Engineers Comments Regarding Surface Water Drainage

Application Reference:	Y/9/25/DOC	Reviewer Reference:	ADC/EXT5/AF
Planning Officer:	Amber Willard	Date of Review:	29/12/2025
Site Name:	Fleurie Nursery Lake Lane Barnham PO22 0AL		
Application Description:	Approval of details reserved by condition imposed under reference Y/26/24/PL relating to condition number 4 - surface water drainage scheme, condition number 5 - discharge flows to watercourses, condition number 6 - maintenance and management of the surface water drainage system and condition number 10 - Biodiversity Enhancement Layout.		
Assessment Number:	4

Application Reference: Y/9/25/DOC Site Name: Fleurie Nursery Lake Lane Barnham PO22 0AL	Initial Issue Date: 21/02/2025 Issue Date: 29/12/2025 Reviewer Reference: ADC/EXT5/AF
--	---

DRAWN	KCK	ENGINEER	TZ	CHECKED	CS	APPROVED	CS
DATE	DECEMBER 2023	SCALE @ A1	1:200				
JOB No.	C2904	STATUS	P	DRAWING No.	101	REV.	P4

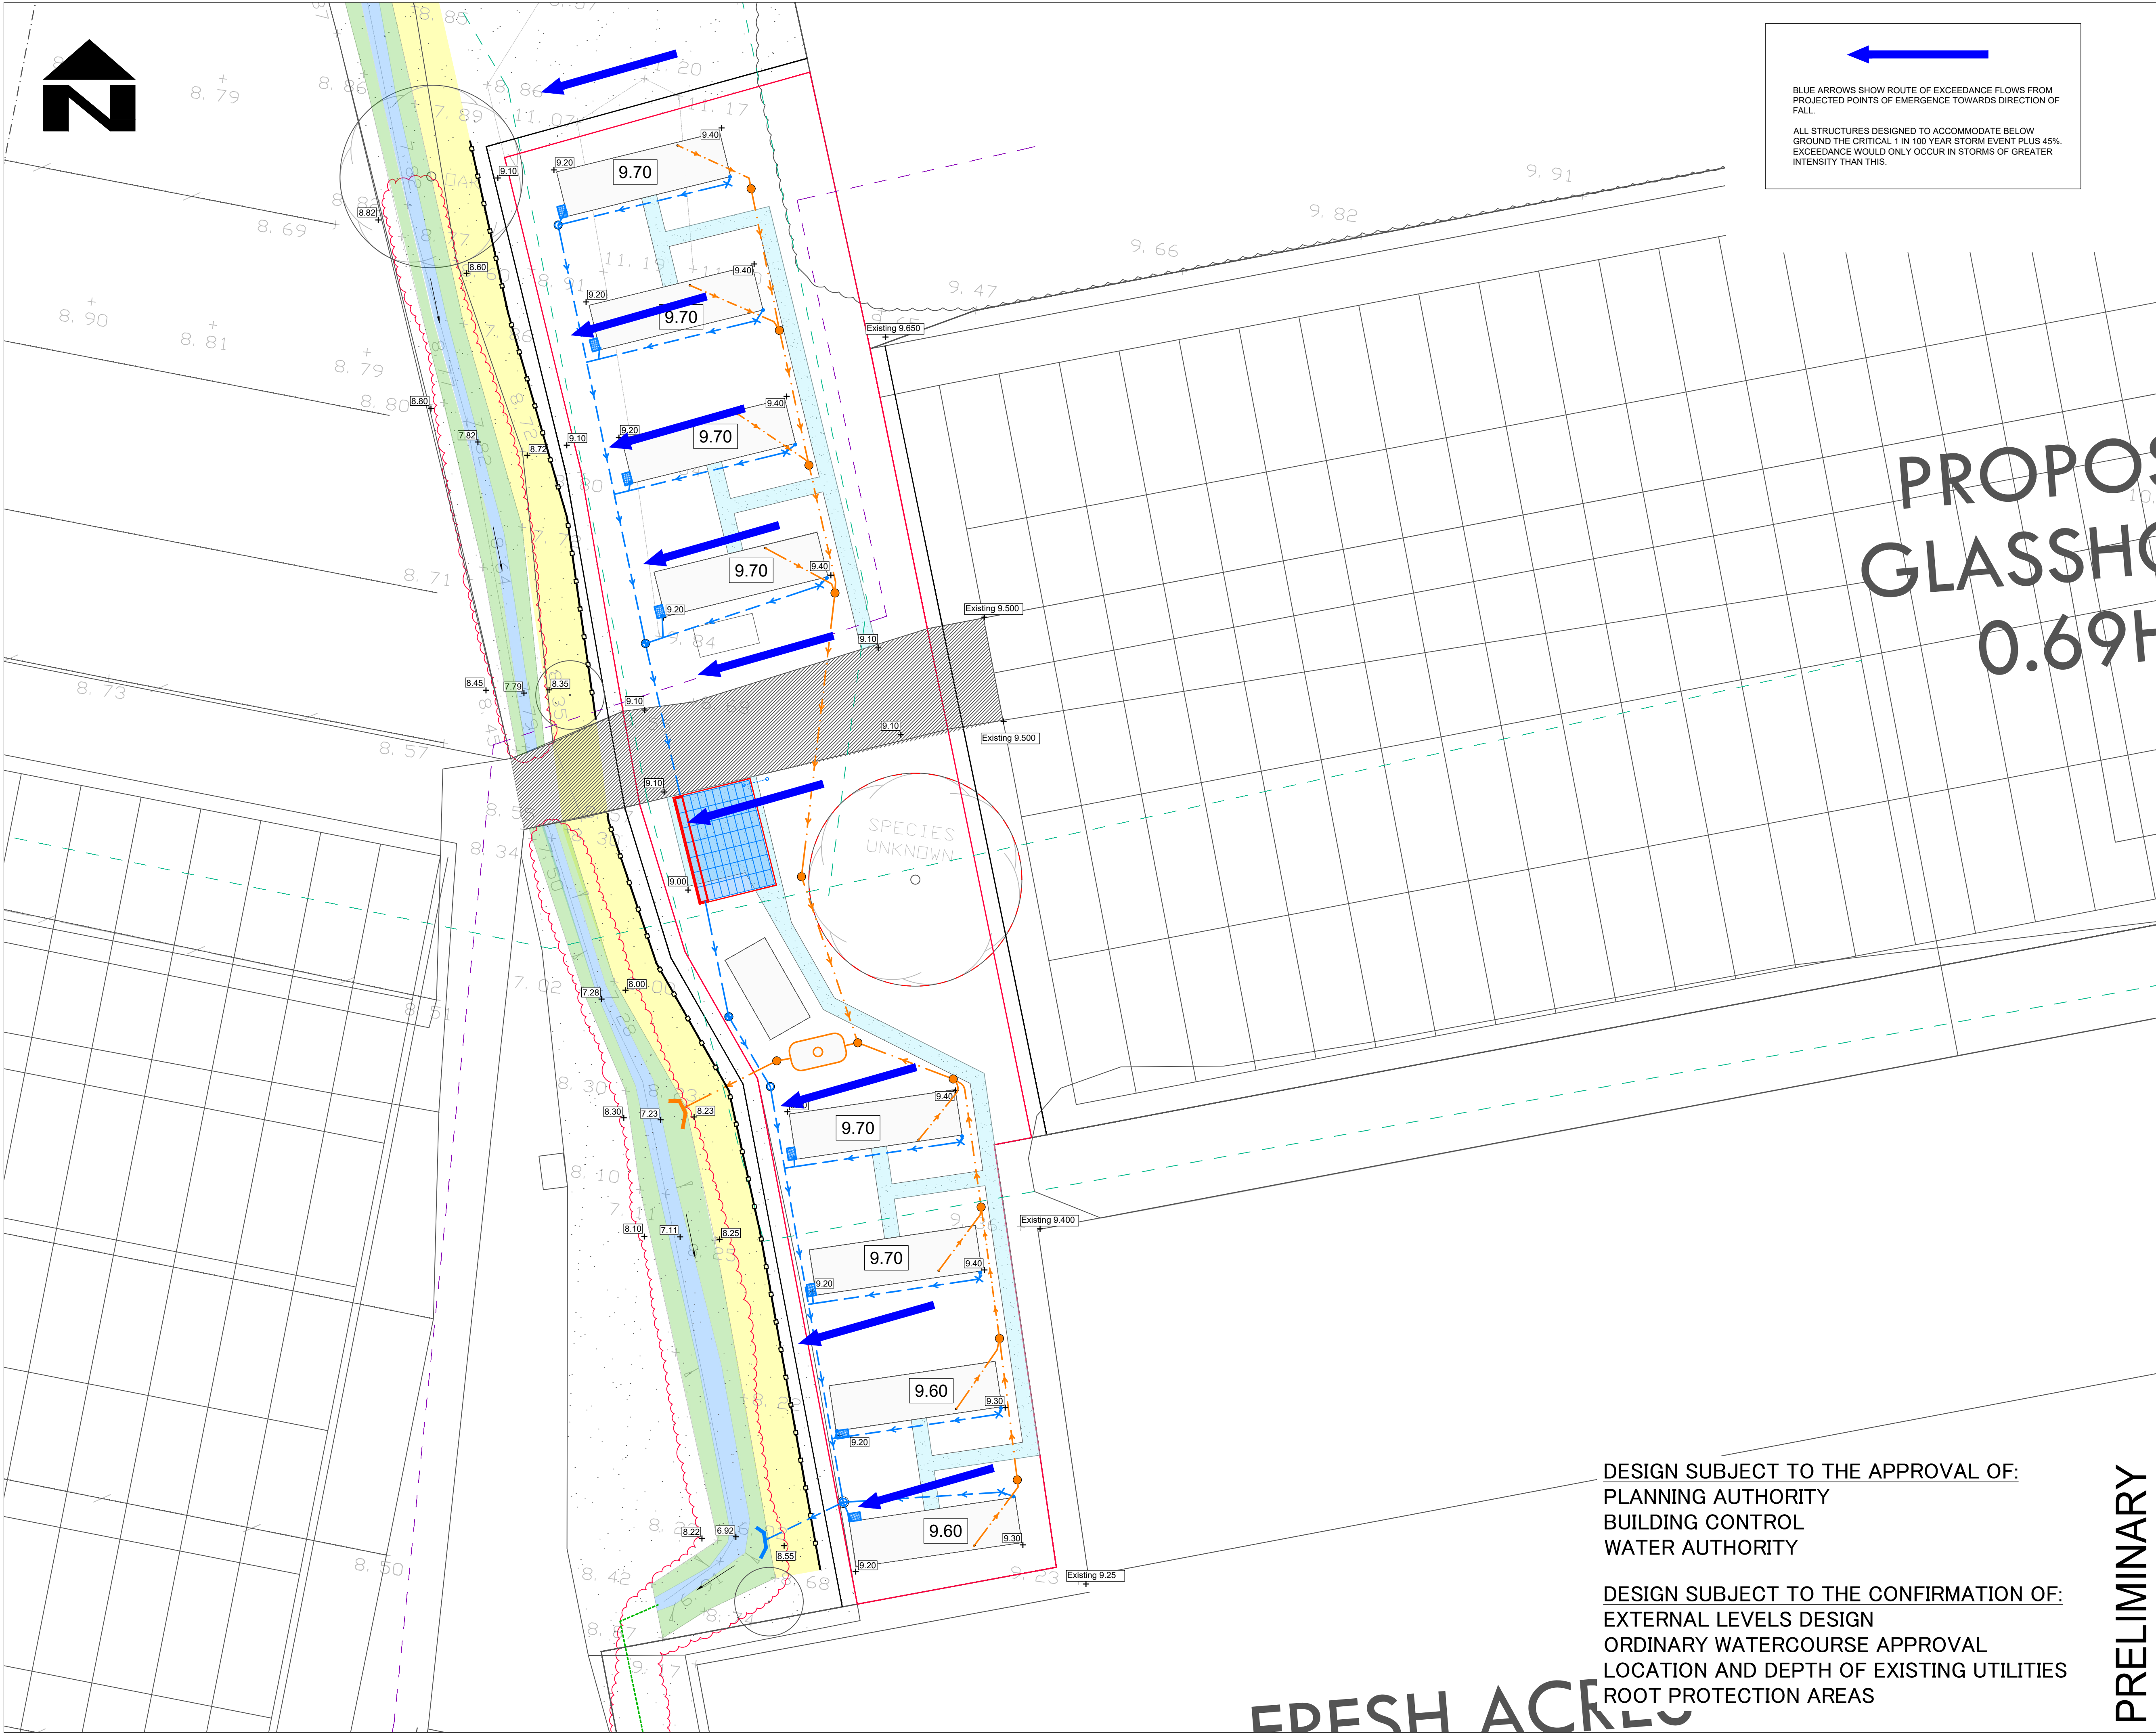
4.	Please correct discrepancies between cover and invert levels on the plans and the calculations. [It is acknowledged that this is unlikely to affect the design.] Designers response 26/03/2025 Discrepancies are now updated, please find the revised drainage plan and drainage calculations attached.	Cover levels for S3 and S4 differ. Please adjust.	Updated.	Drawing revision C2904 P101 rev P5 acceptable. Comment closed.	COMMENT CLOSED

6.	Please show any relevant easements on the plans. Designers response 26/03/2025 The existing watercourse 3m easement is now indicated on drainage plan	Noted and accepted. Comment closed.	COMMENT CLOSED

post-development to protect the rife. Please clearly demark this fence on the plans and ensure that is not within the easement for the watercourse. Designers response 26/03/2025 The proposed post and rail fence is now indicated on the proposed drainage plan. Proposed fence is to be located min. 3m away from the top of the banking (easement).				
10.	The existing access appears to be artificially raised (previous level 8.55, proposed level 9.10). This is also an area of surface water flood risk – see comment 7 – please justify the change in level and demonstrate any impact on flood risk. Designers response 26/03/2025 As per the response to comment 7, access road is to raised to meet the proposed site levels. Access road will be graded following the existing site levels with a slope toward the existing watercourse to mimic the	Noted and accepted. Comment closed.	COMMENT CLOSED

existing runoff discharge regime.				
11.	The orifice for S5 is described on the layout as being 500mm diameter. This is assumed to be a typo (confused with the chamber diameter), please correct. Designers response 26/03/2025 Orifice chamber diameter has been updated to 600mm diameter and orifice diameter to 20mm.	Orifice chamber is shown as 900mm diameter. 20mm orifice noted. Comment closed.	COMMENT CLOSED		
12.	The modelling does not include the flap valve. Designers response 26/03/2025 Flap Valve is now included	Noted and accepted. Comment closed.	COMMENT CLOSED		
13.	Please remove the standard (non-site specific) headwall details from C2904-P-501. These contradict the OWC drawings which are more detailed and site specific. Designers response 26/03/2025 Headwall detail has been removed. It should be noted that OWC drawings have been issued	Noted. Comment closed.	COMMENT CLOSED

Sel Controflow 600-900Ø Orifice Chamber

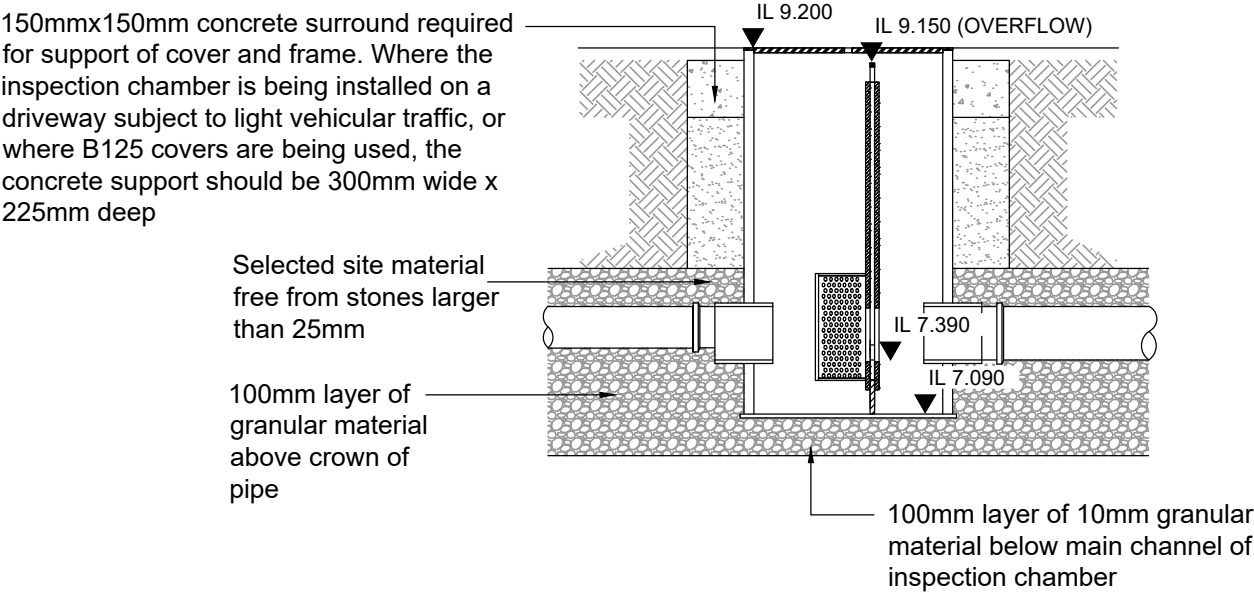
and comments have been received. Drawings are now updated and the updated drawings has been issued for final review.				
14.	Please detail the overflow level of the Sel Controflow 500 Orifice Chamber. Designers response 26/03/2025 Overflow level is now indicated on orifice chamber detail.	It is noted that the overflow level of 9.150 is higher than manhole S3 cover level (9.00) upstream, so in the event of a blockage at the orifice, excess water may overflow from S3 before the formal overflow at S5 operates. Please advise.	Updated. The overflow level has been lowered and is now set at 9.025.	Drawing revision C2904 P101 rev P5 has been adjusted to show an overflow level of 9.025. The construction details drawing should be updated to suit. The construction detail for the attention arrangement should demonstrate how the vent pipe outlet will be above the overflow level, or the overflow level reduced below the cover level for the storage. Designers response 09/12/2025 Updated.	Drawing revision C2904 P101 rev P6 has been adjusted to show a vent pipe position. The construction details drawing C2904 P501 rev P3 has been updated to include the vent pipe, which is above the overflow level. Comment closed.
